Your Ref: OWPC24784
Our Ref: LU/299/19/PL
Please ask for:
Mr A Wood

Upgrade of football pitch floodlights.
Littlehampton Town Football Club The Sportsfield St Flora's Road Littlehampton

Thank you for your internet comments made on 13th November 2019 which has been recorded as **'no objection'** with the comments as follows:

PROPOSED LUX LEVELS

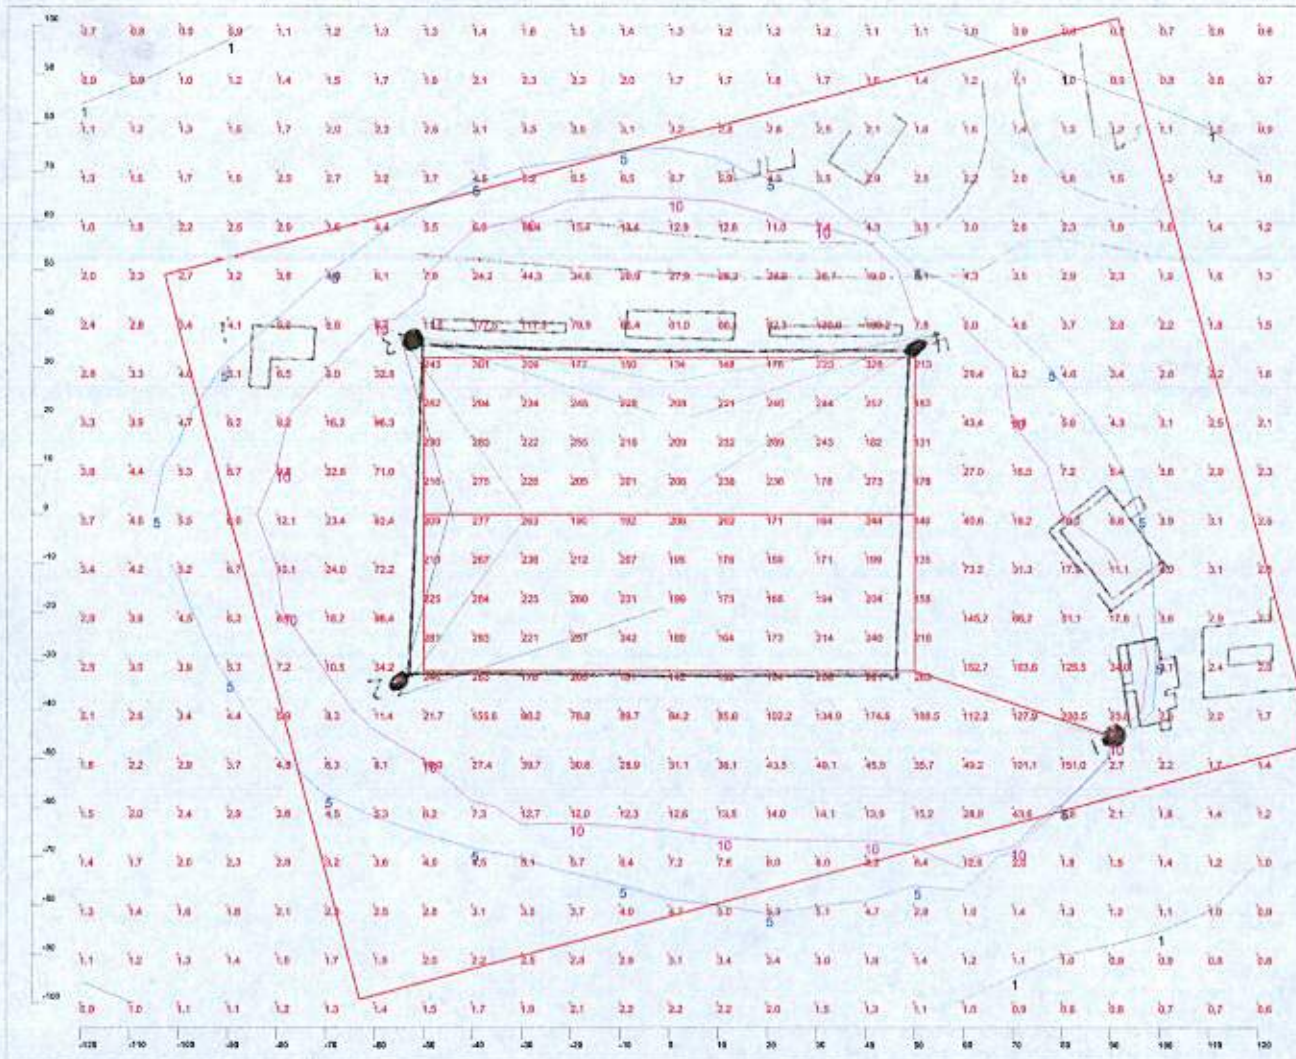
This application was considered by the Town Council's Planning and Transportation Committee at the meeting held on Monday 11th November 2019. The Committee had no objection to the proposals providing that the direction of the lighting was positioned so as not to compromise highways safety particularly in respect of Church Street or have an adverse impact on the neighbouring residential properties.
